Online Comment

Application H22-0058-23
Location 28 Broadgate Weston Hills Spalding PE12 6DQ
Proposal Demolition and replacement of existing dwelling including change of use of agricultural land to residential curtilage

Name Ian Marshman, Historic Environment Officer
Address Lincolnshire County Council Lancaster House 36 Orchard Street Lincoln LN1 1XX

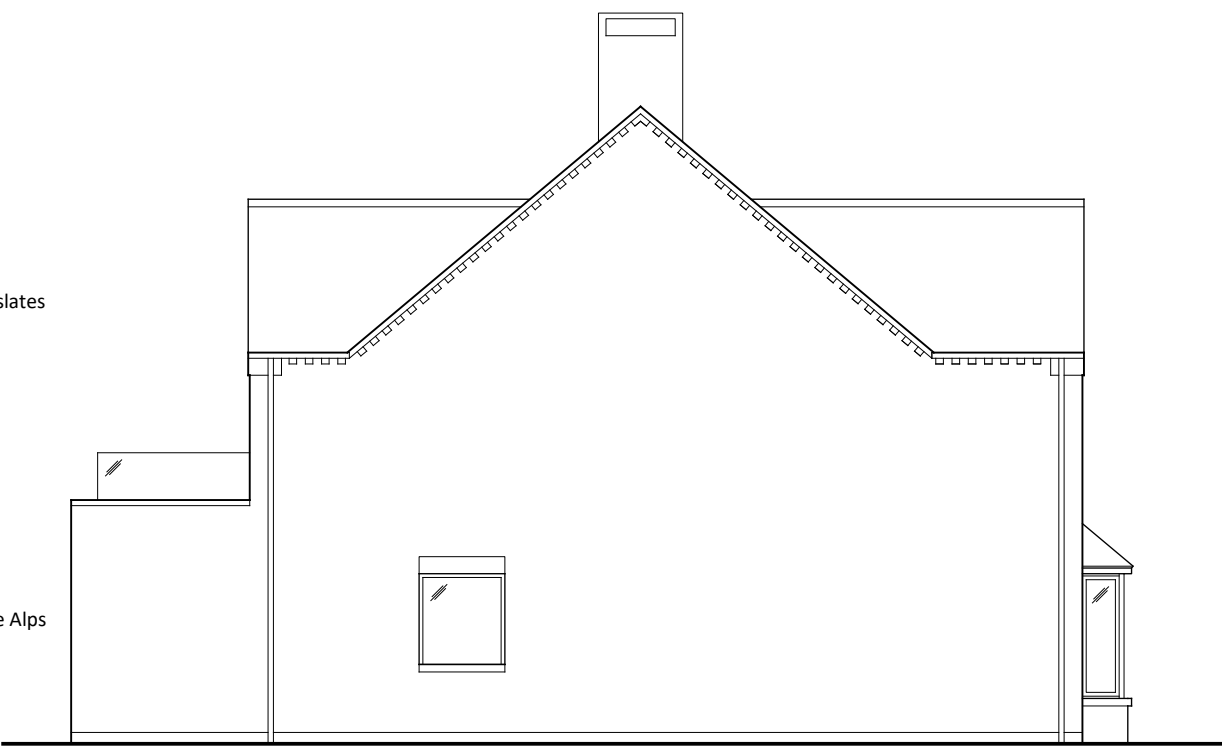
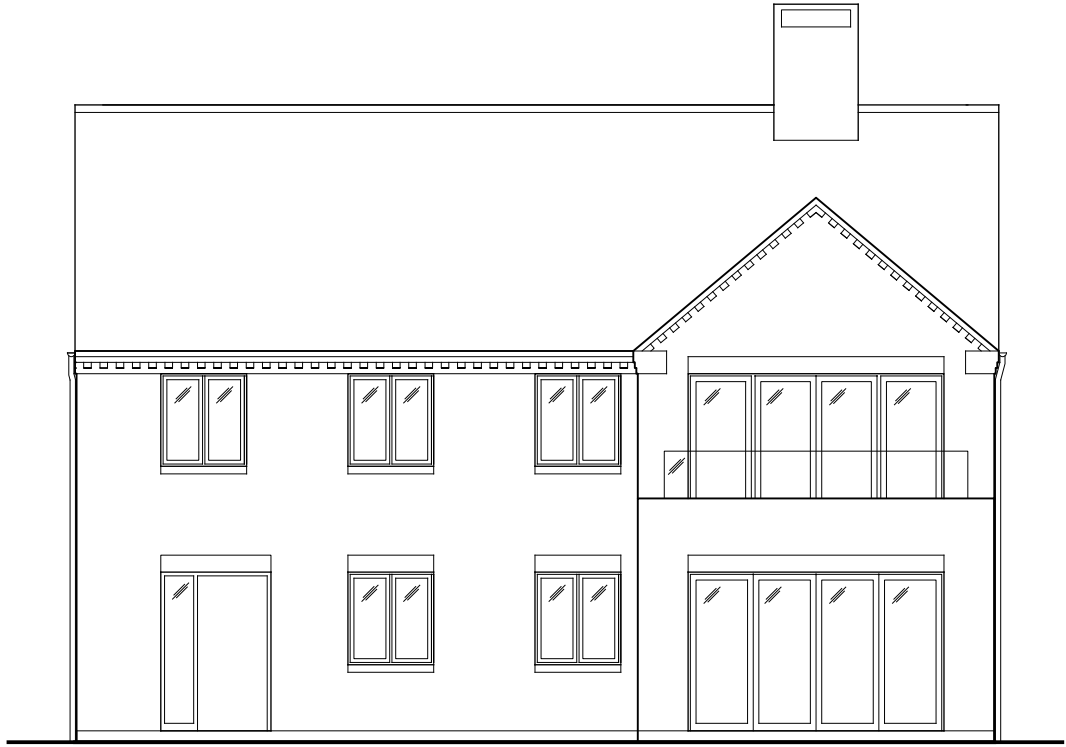
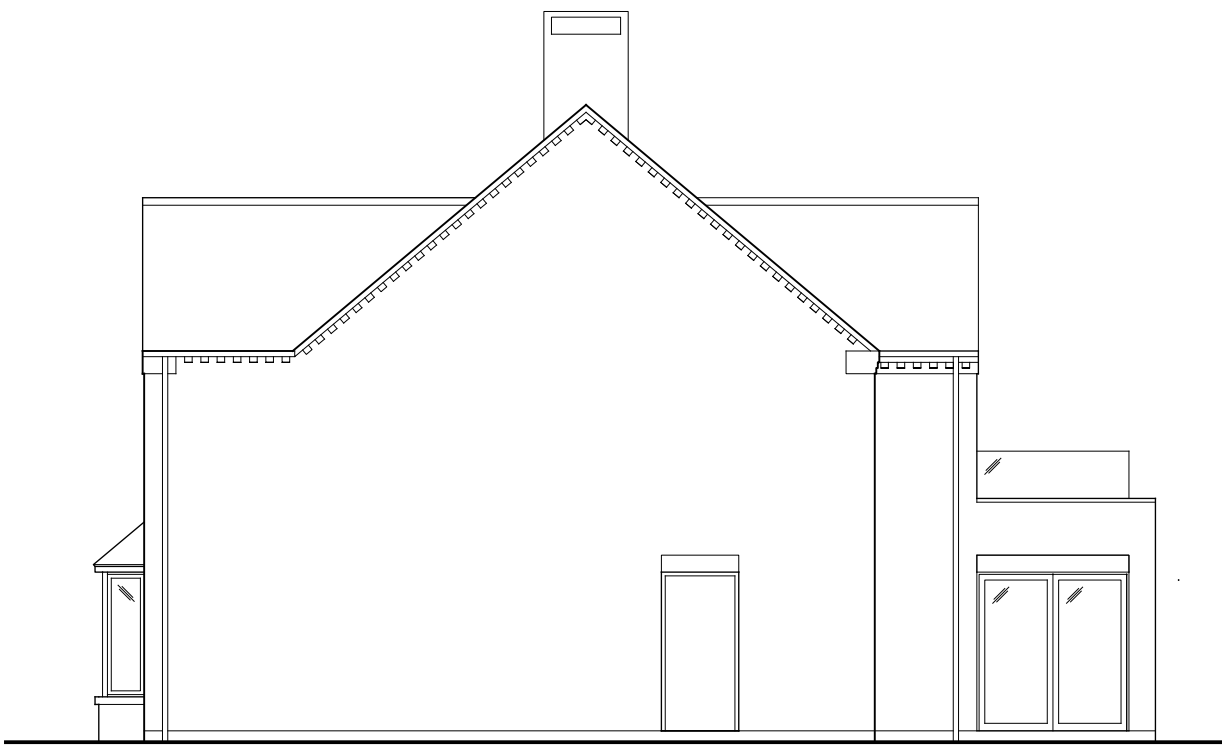
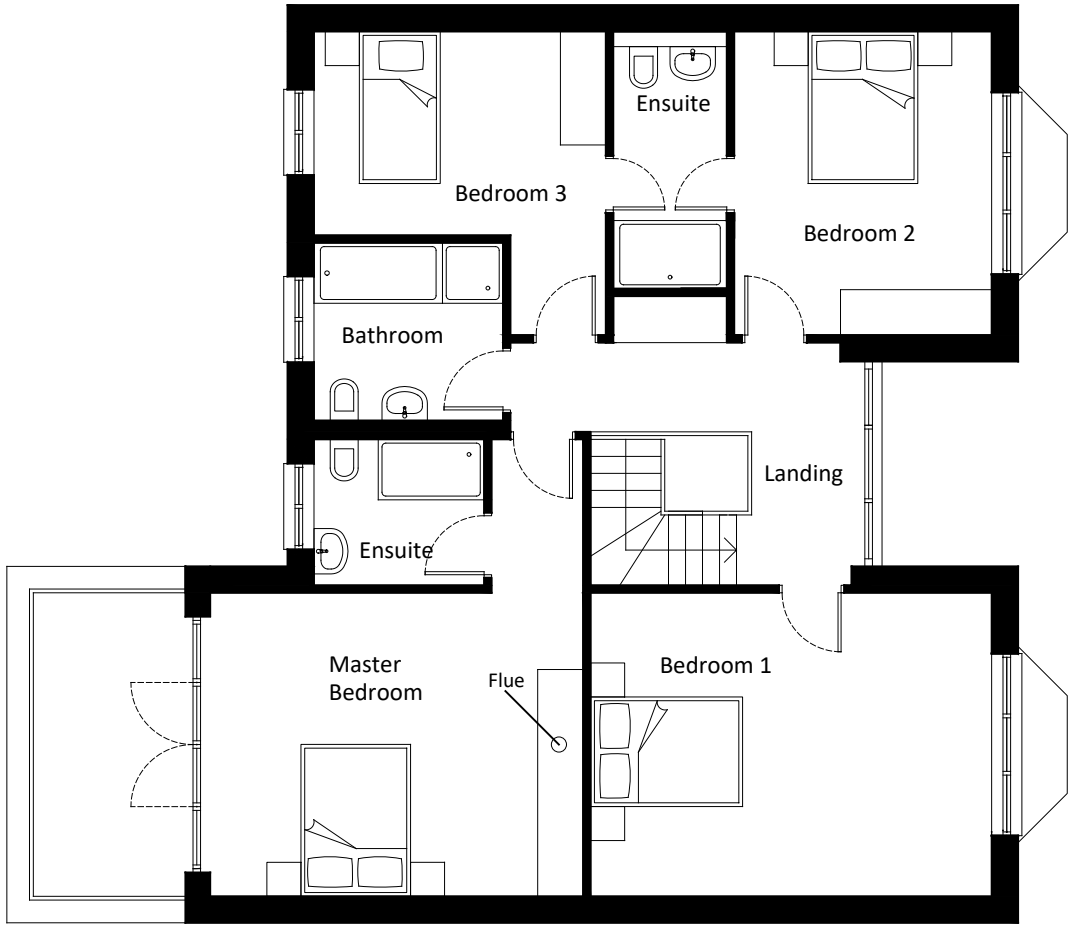
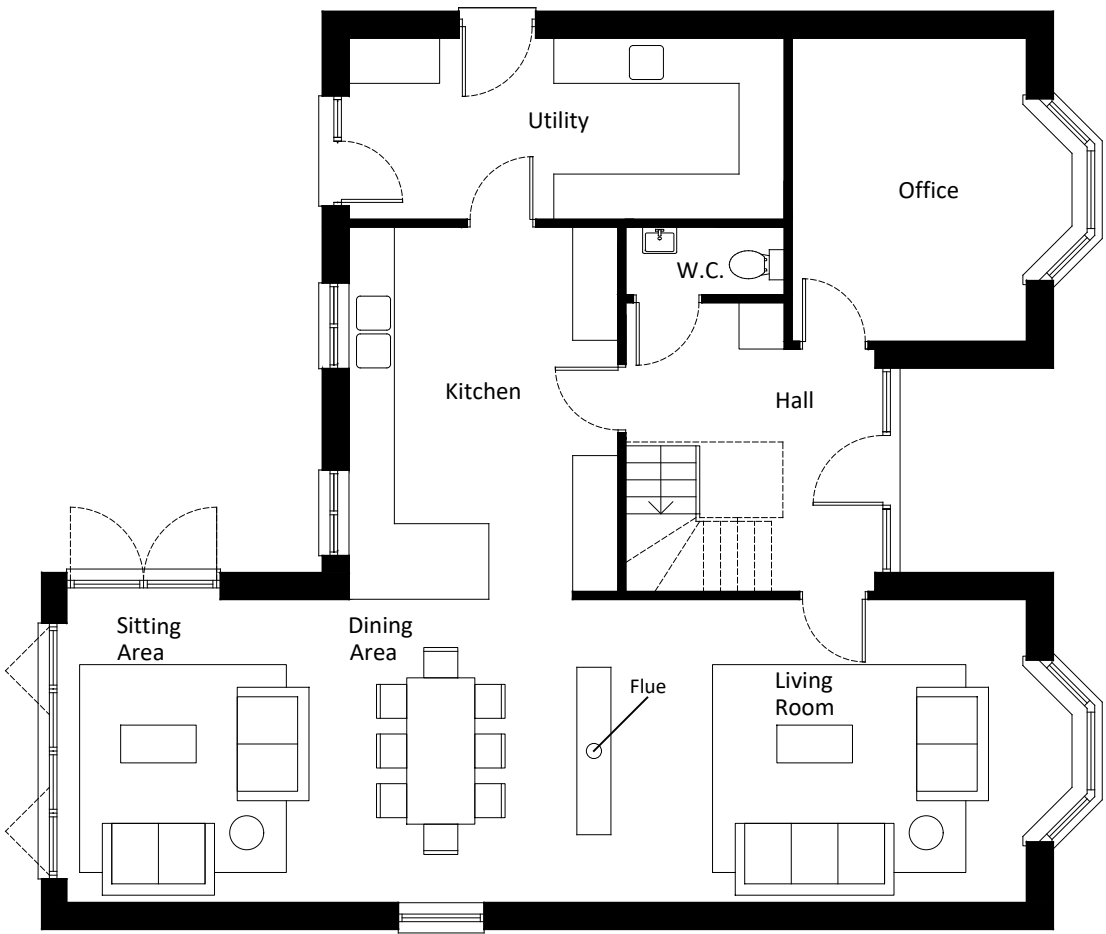
It is disappointing that the proposed replacement dwelling does not appear to take inspiration from its predecessor, or fenland character and distinctiveness.
